**OXFORDSHIRE COUNTY COUNCIL'S RESPONSE TO CONSULTATION ON THE
FOLLOWING DEVELOPMENT PROPOSAL**

Application no: 14/02156/OUT

Proposal: Outline application for up to 95 no. new homes

Location: Land South of Cotefield Business Park, Oxford Road, Bodicote

Figure 22: Potential Footpath Network Improvements

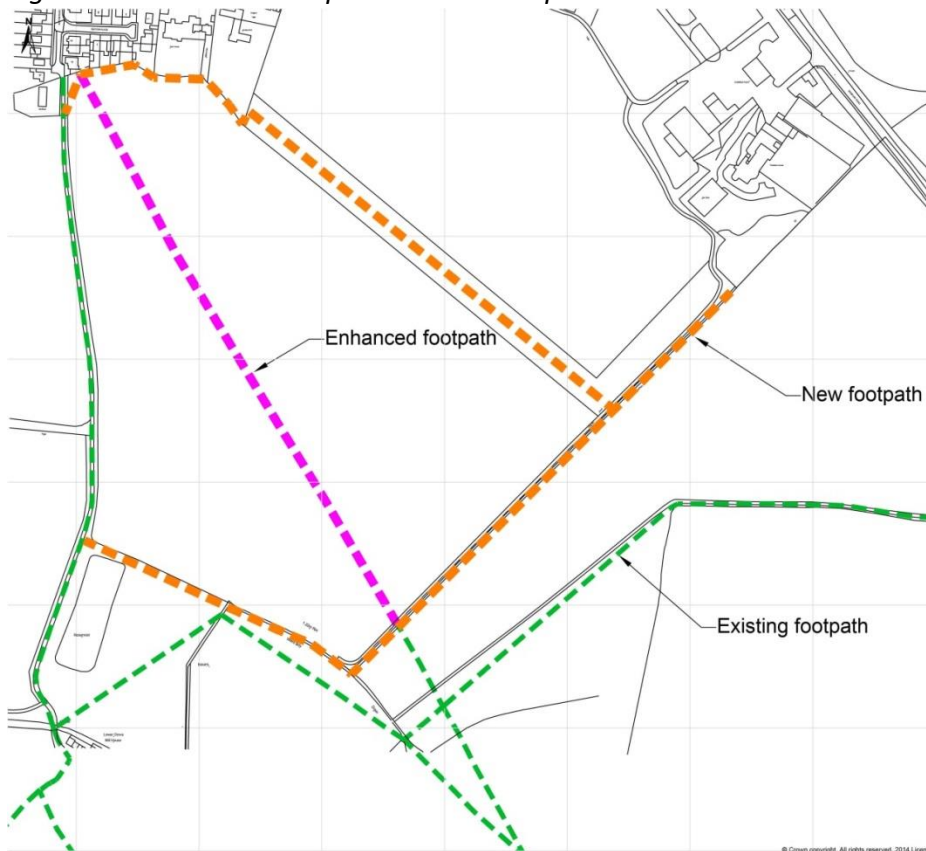
The proposals mention that the existing footpath (Bodicote Footpath 6) that runs across the field (and is marked on the plan) will be enhanced; however I can't find any information on how this will be enhanced.

Plan 7993-0060-01 shows the most southerly proposed path (running from Bodicote bridleway 4 in a south-easterly direction and then turning to run in a north-easterly direction up to the development) as being located to the south of the boundary. I would question

whether this route should be shown to the north of this boundary where this appears to be provided on the ground at the moment?
